Our ref: CE/2009/102791/01-L01
Your ref: 3/2009/0538P
Date: 03 August 2009

**PROPOSED REAR SINGLE STOREY EXTENSION
25 KNOWSLEY ROAD, WILPSHIRE**

23 / 25 KNOWSLEY ROAD WILPSHIRE
BLACKBURN LANCASHIRE BB1 9PX
PROPOSED TWO STOREY SIDE EXTENSION TO 23
AND REAR SINGLE STOREY EXTENSION TO 23 AND 25
scale 1 : 100 drawing 20 : 09 : 879 : 2
J J Taylor M. R. I. C. S.
Chartered Surveyor
31 Dent Dale Accrington
BB5 6 RL 01254 384711

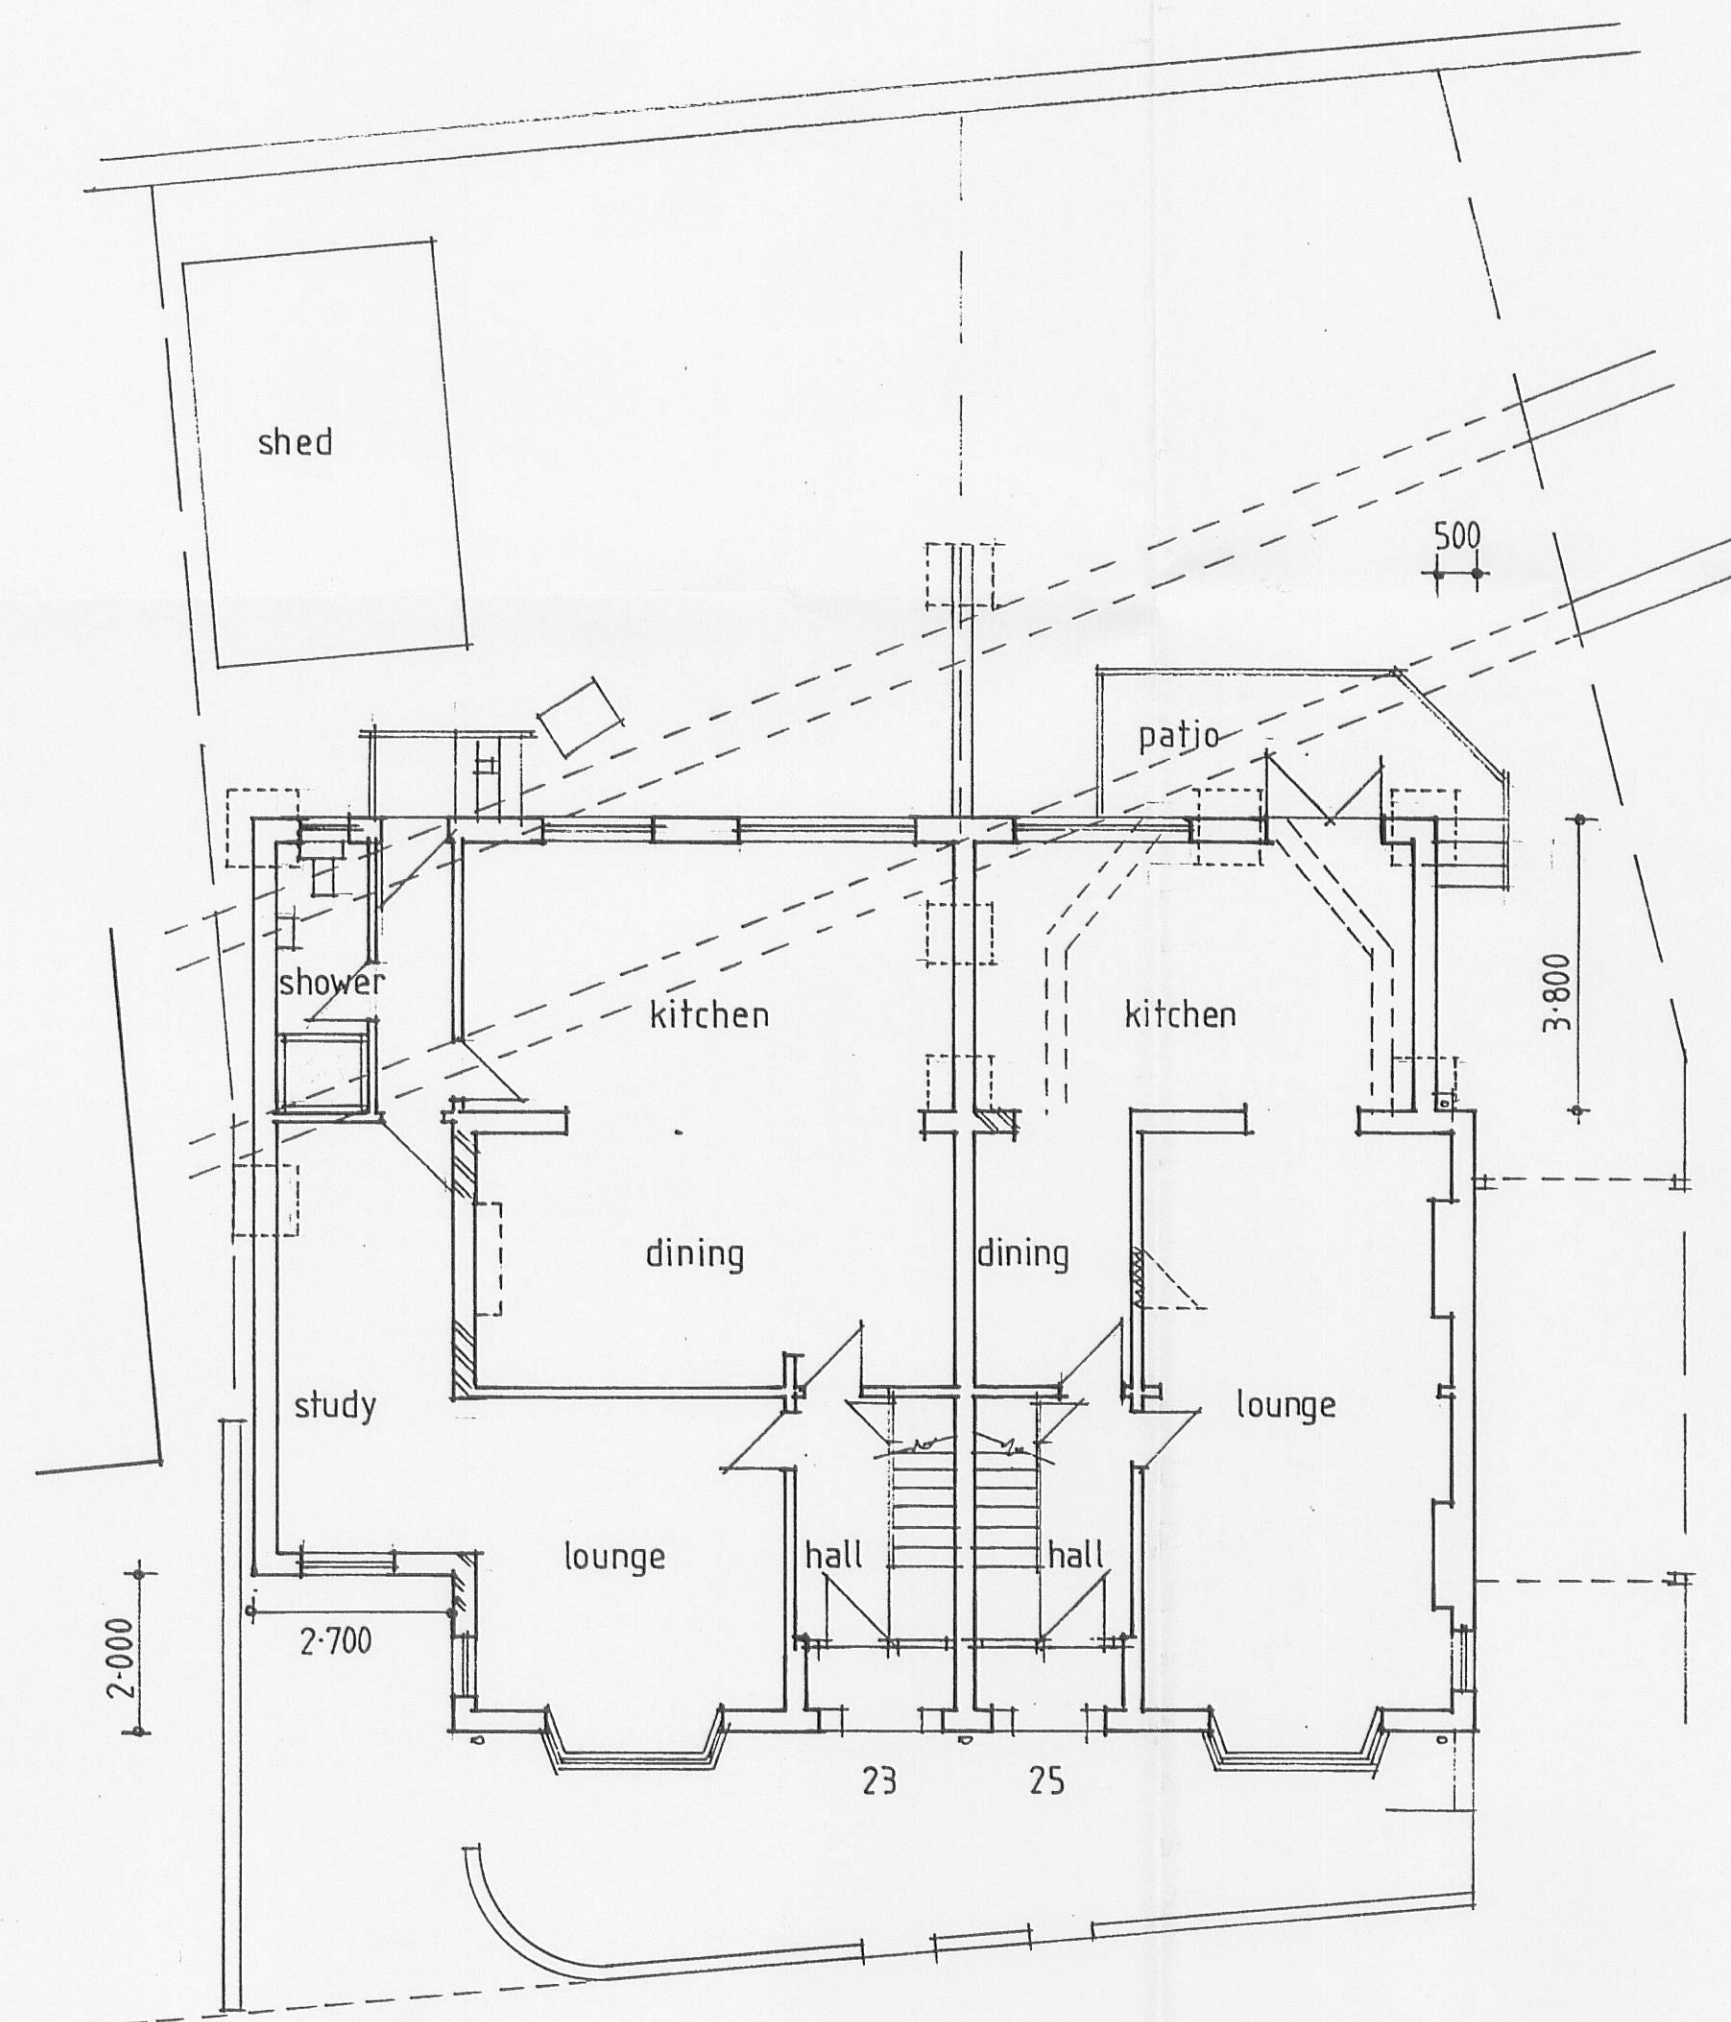
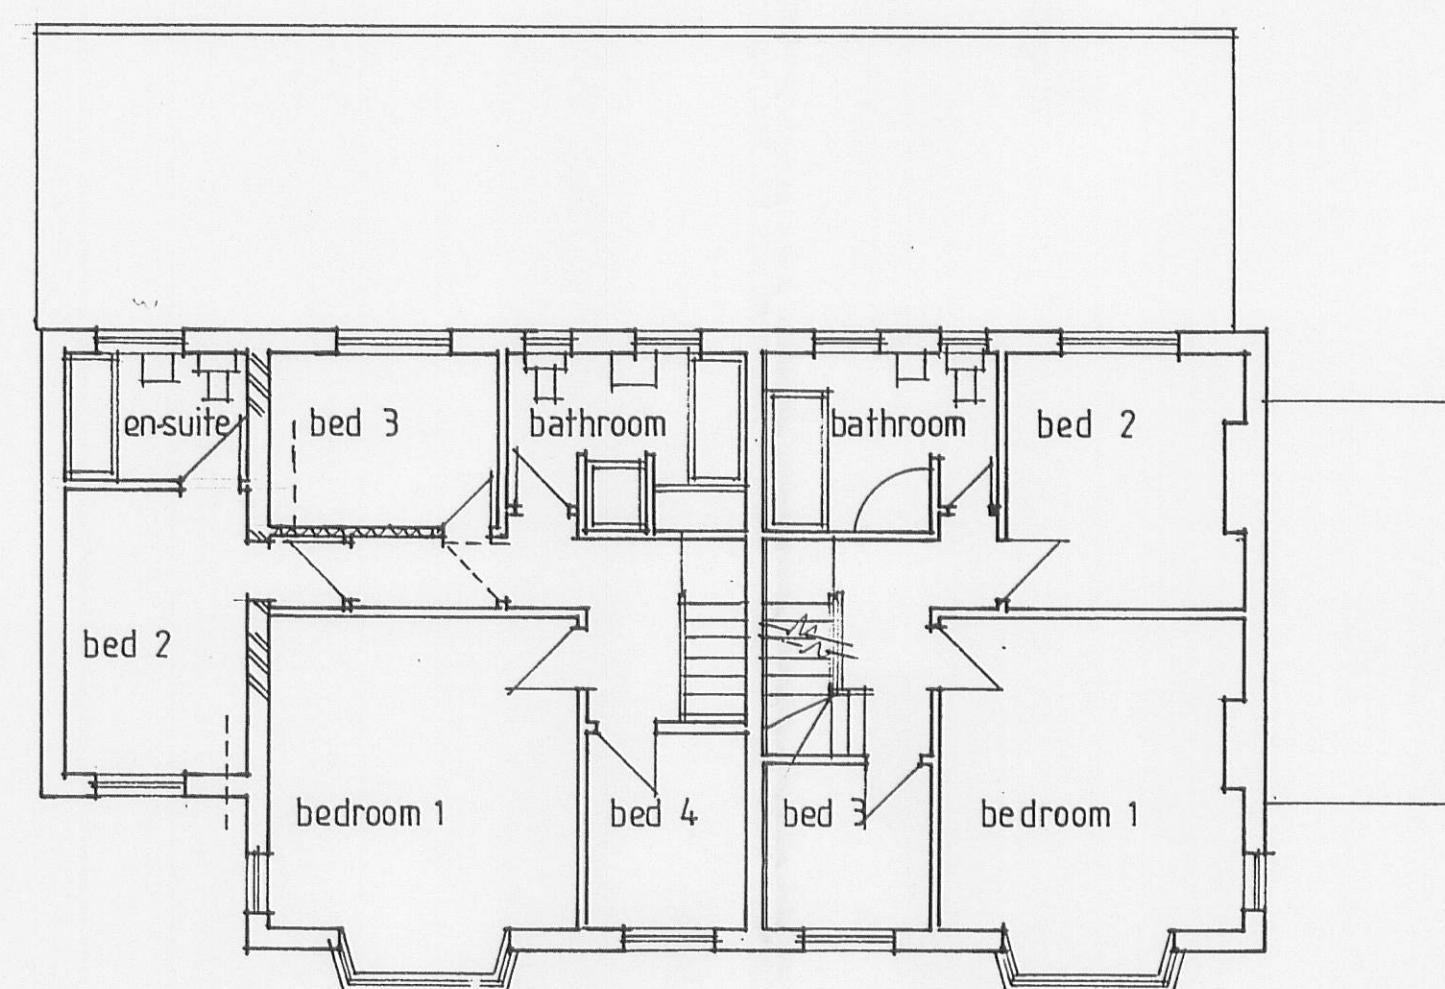
The proposal is above a culverted watercourse. Development above culverts is not considered good practice, as it will prejudice future replacement restoration and can restrict necessary access to the watercourse. We cannot control any development over the existing culvert, and we feel this matter should be agreed before the granting of any planning permission. To overcome our concerns, the applicant would need to amend the layout of the proposed development such that there was no new development over the culvert.

Any works to the watercourses within or adjacent to the site which involve infilling, diversion, culverting or which may otherwise restrict flow, require the prior formal Consent of the Environment Agency under Section 23 of the Land Drainage Act 1991. Culverting other than for access purposes is unlikely to receive Consent, without full mitigation for loss of flood storage and habitats.
